Replacement Boundary Wall to Southern Boundary of Property

Replacement Wall 11/12 Cross Street

New Entrance Gate - Front Elevation
 @ 1:20

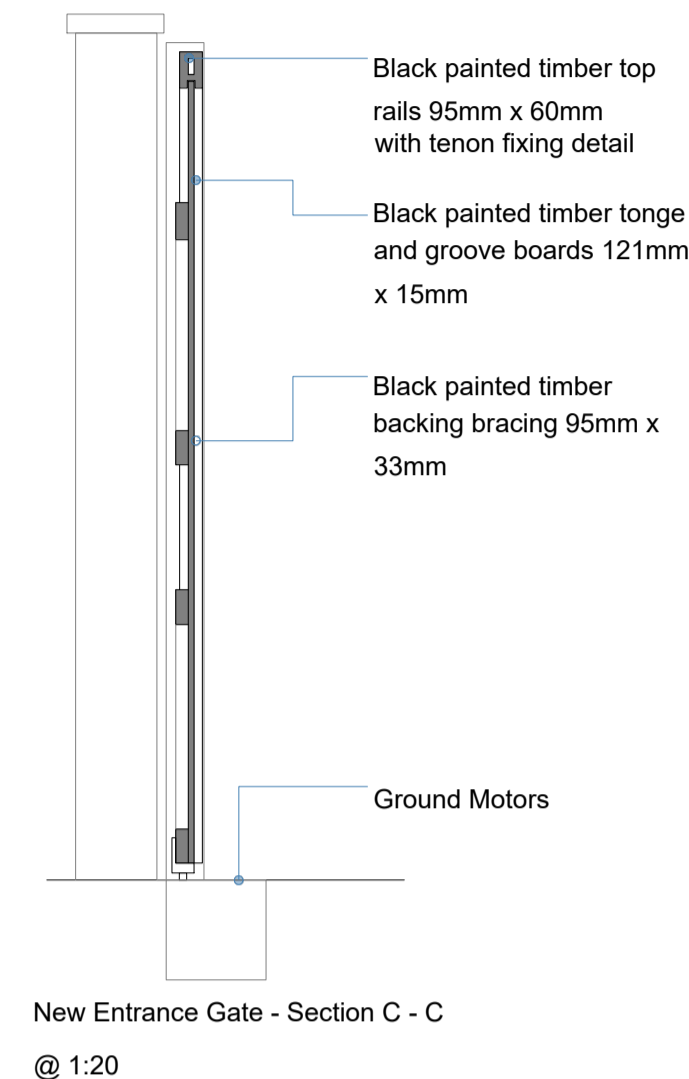
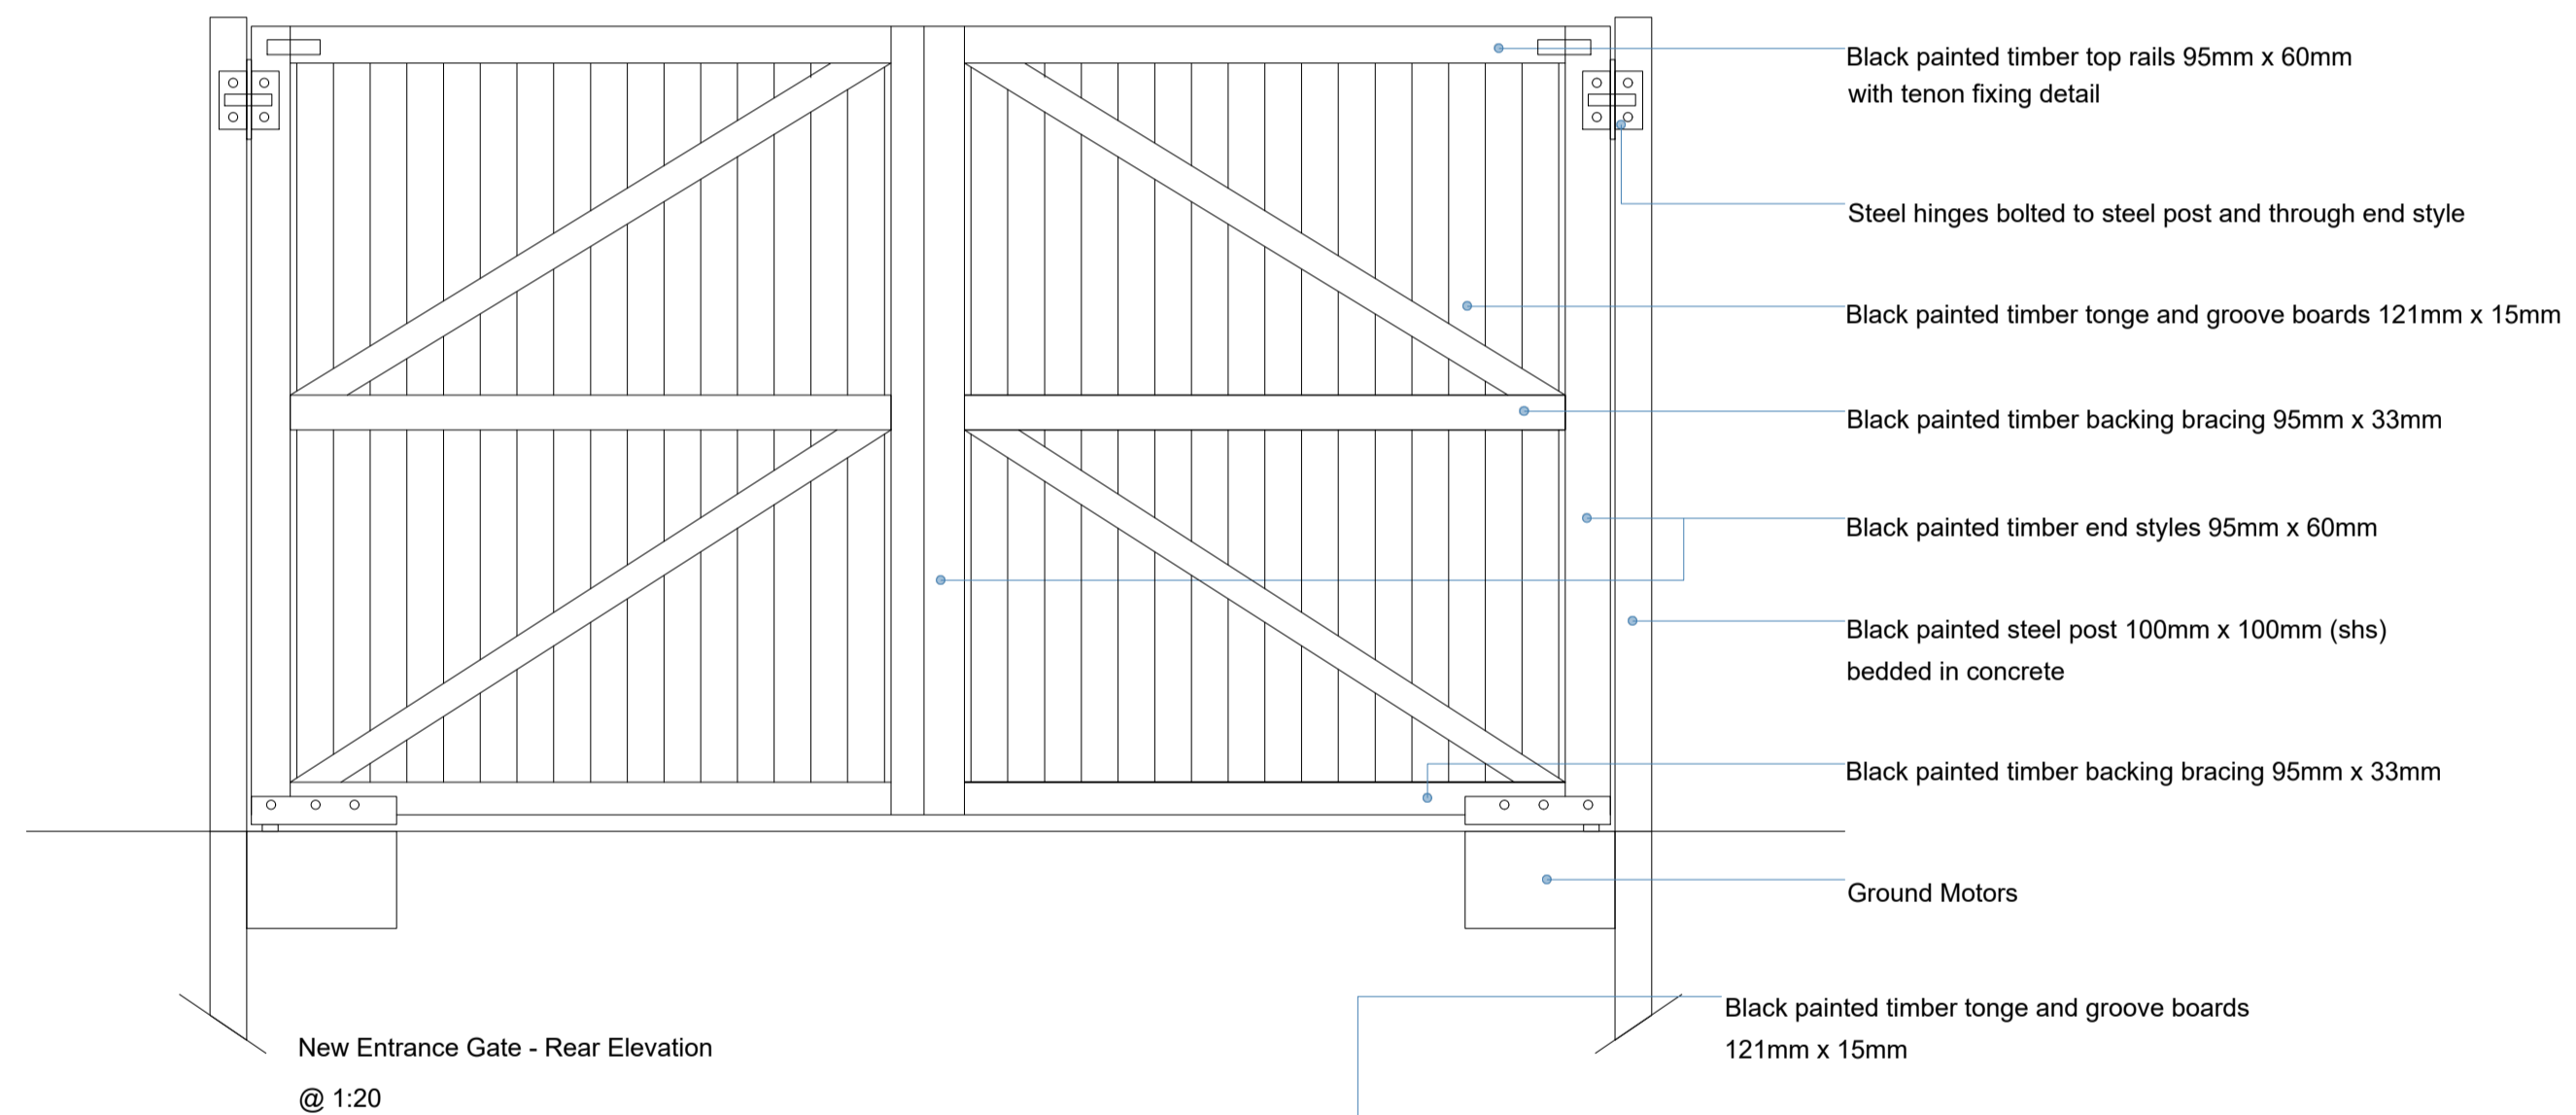
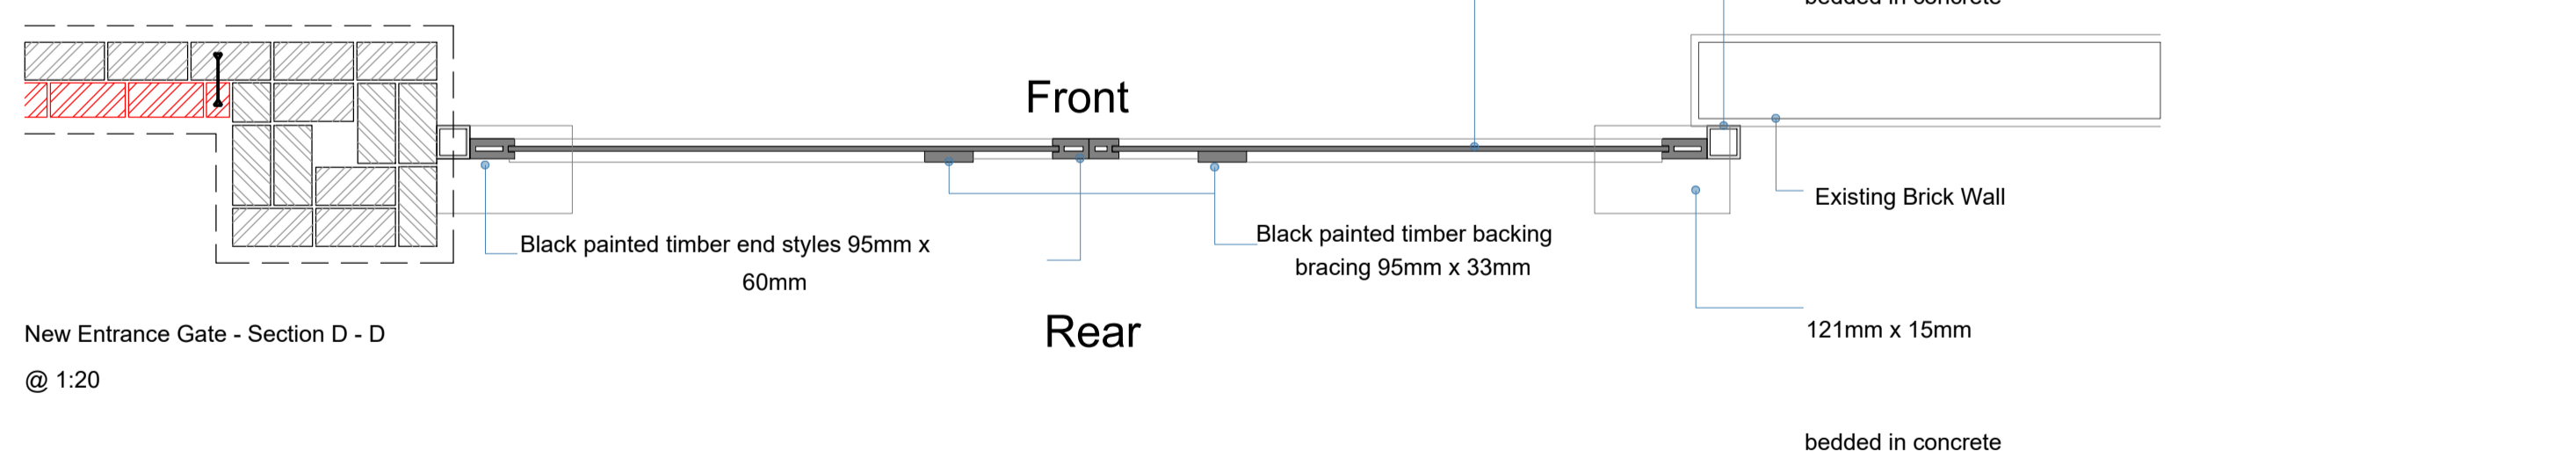
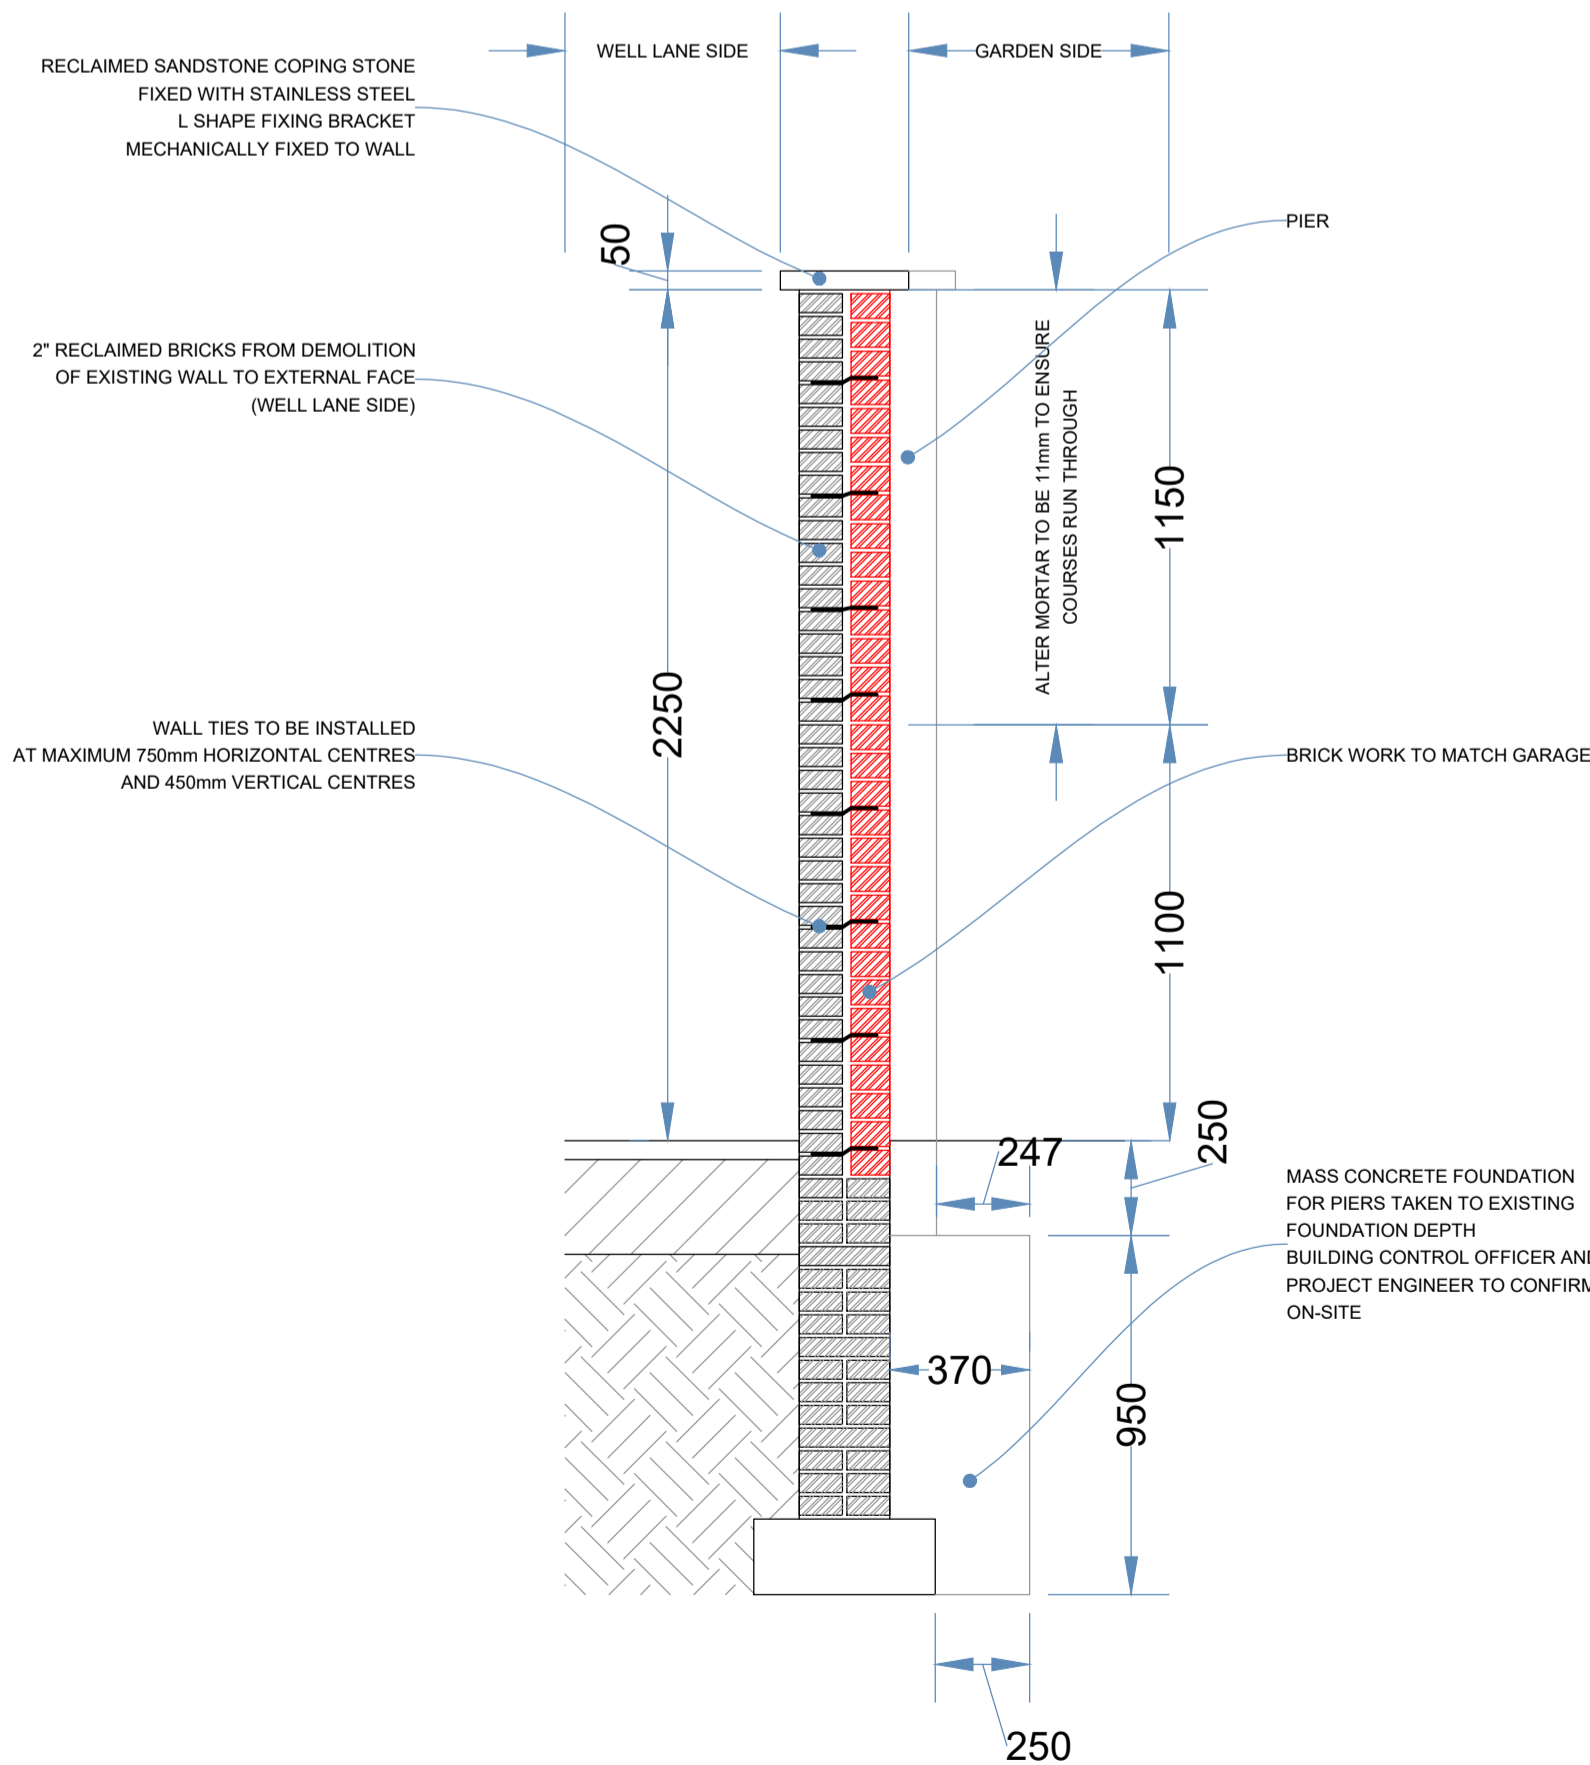
- 1) It is proposed to install stone coping at the top of the wall- was this in situ when the wall came down, or proposed to be introduced because it would be to the benefit of the long term construction of the wall?
- 2) I see that the proposed gate details appear to match those proposed as part of the previous 2021 approval on the site- can you confirm this is the case?
- 3) We will need a supporting method statement with any application, which should include the necessary specifications for elements of the works such as mortar mix and pointing profile. We would also want to see a sample of a new brick.
- 4) You will also need to look through our validation requirements to make sure that you are including all the additional information they are going to need before they can validate it (location plan, heritage statement etc.)
